## Accessibility Concept SSD Review

**Project Title:** Hammond Care Seniors Living  
Greenwich Hospital Development, River Road  
Greenwich.

**Date:** 13 September 2019

**Report Version:** ADR\_9144\_v1.4

2 ROUTE TO BUS STOP
1 : 250

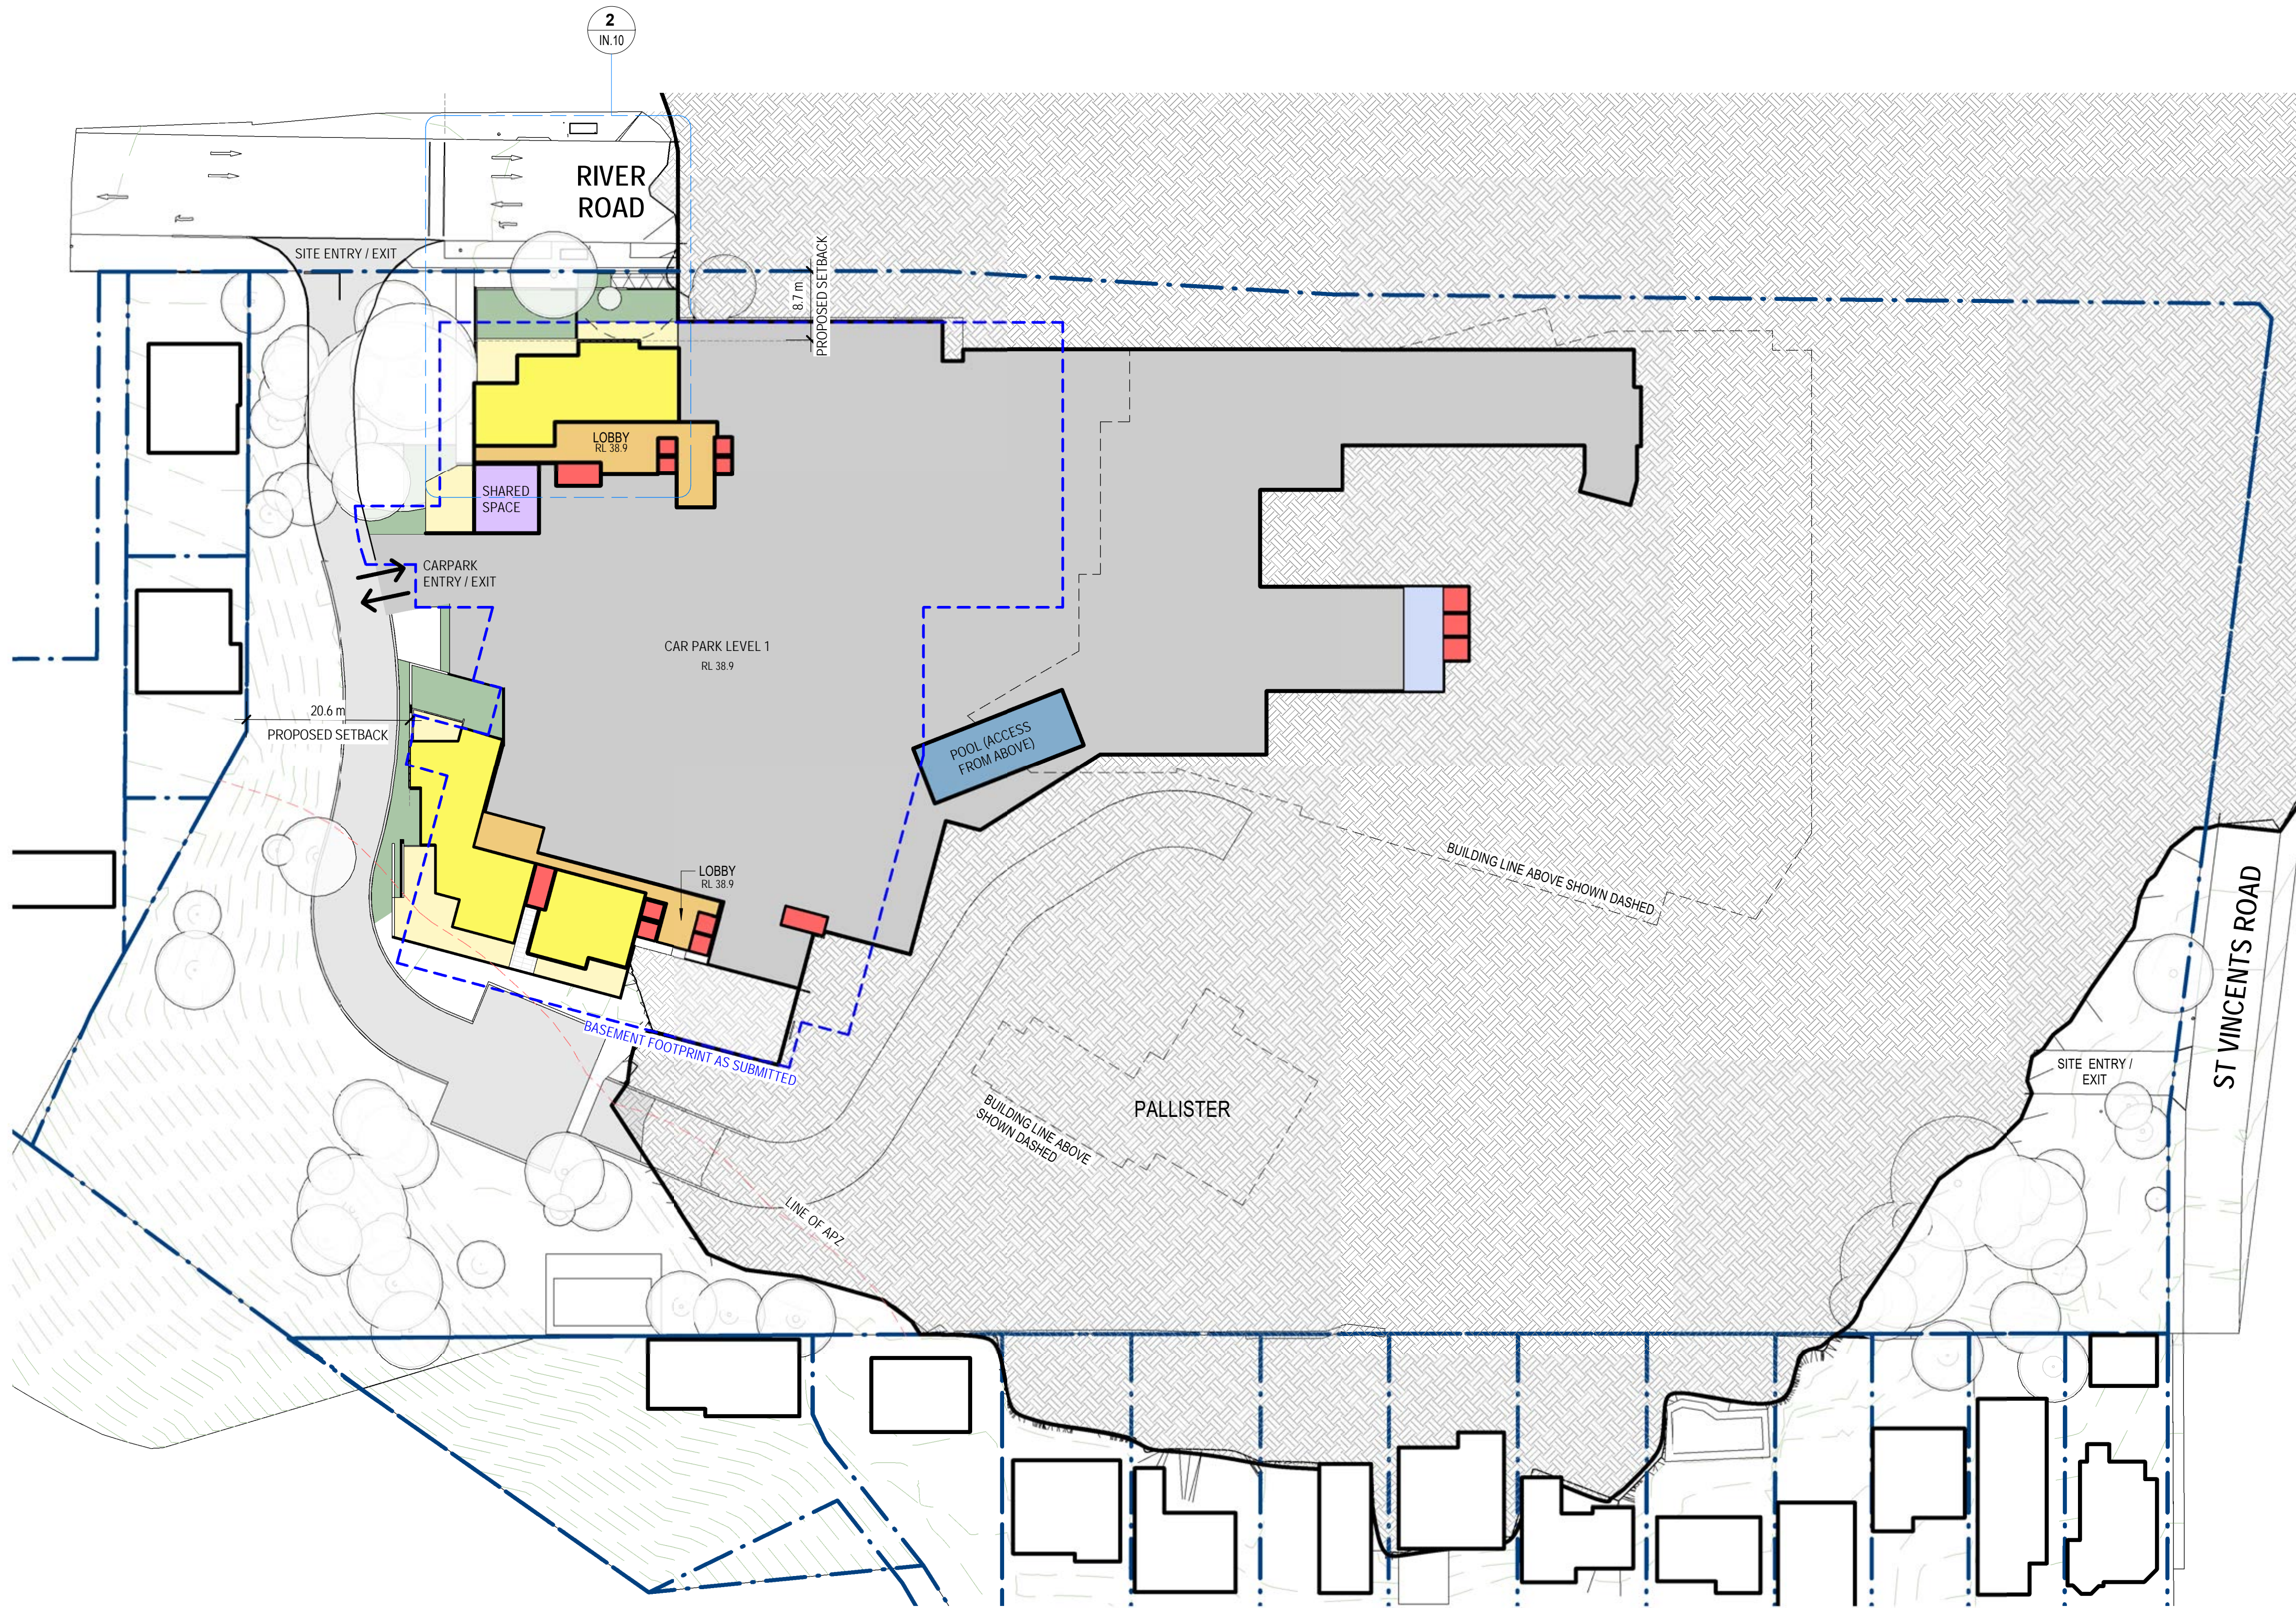
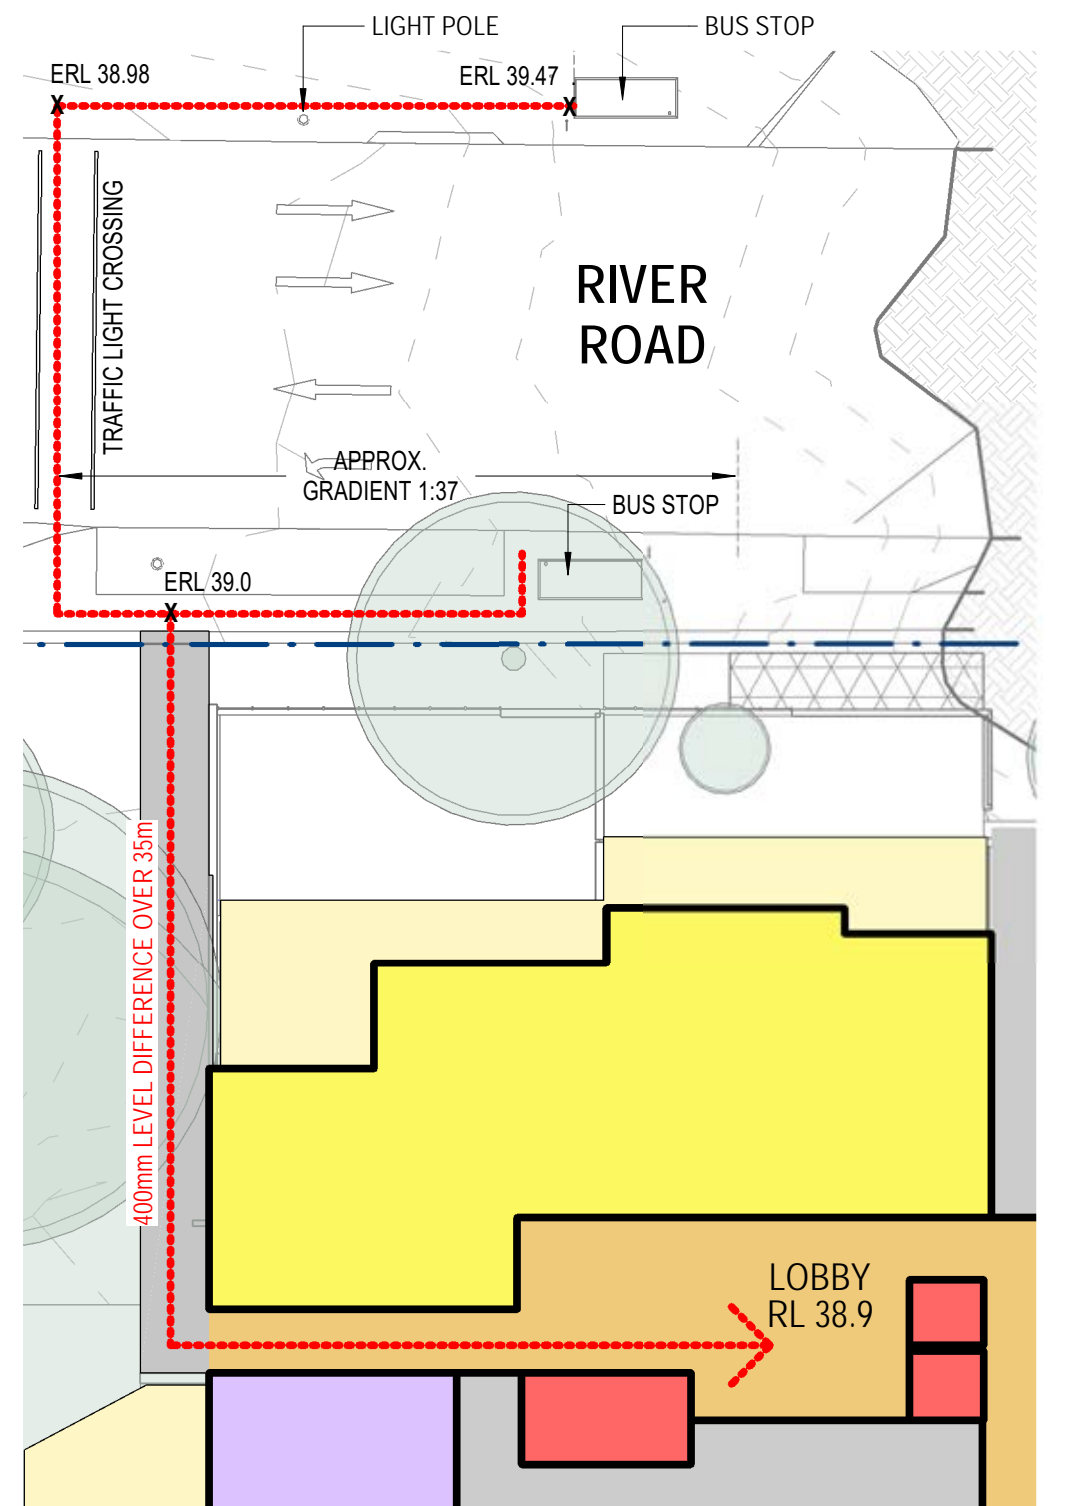
A site survey carried out by LTS Lockley, indicates that the footpath from the site to the bus stop on the south side of River Road is provided with an average gradient of 1:38.9. Our own measurements concurred with aforementioned and although there are parts of this path which vary on the steeper side to this average the length of such variations is within the tolerances permitted under SEPP clause 26(2)(a), refer **Photo 1** below.

**Photo 1** – view along south side of River Road towards bus stop. The survey indicates that the footpath from the site to the bus stop on the north side of River Road is provided with an average gradient of 1 in 33; our own measurements taken on site concurred with this also, refer **Photo 2** below.
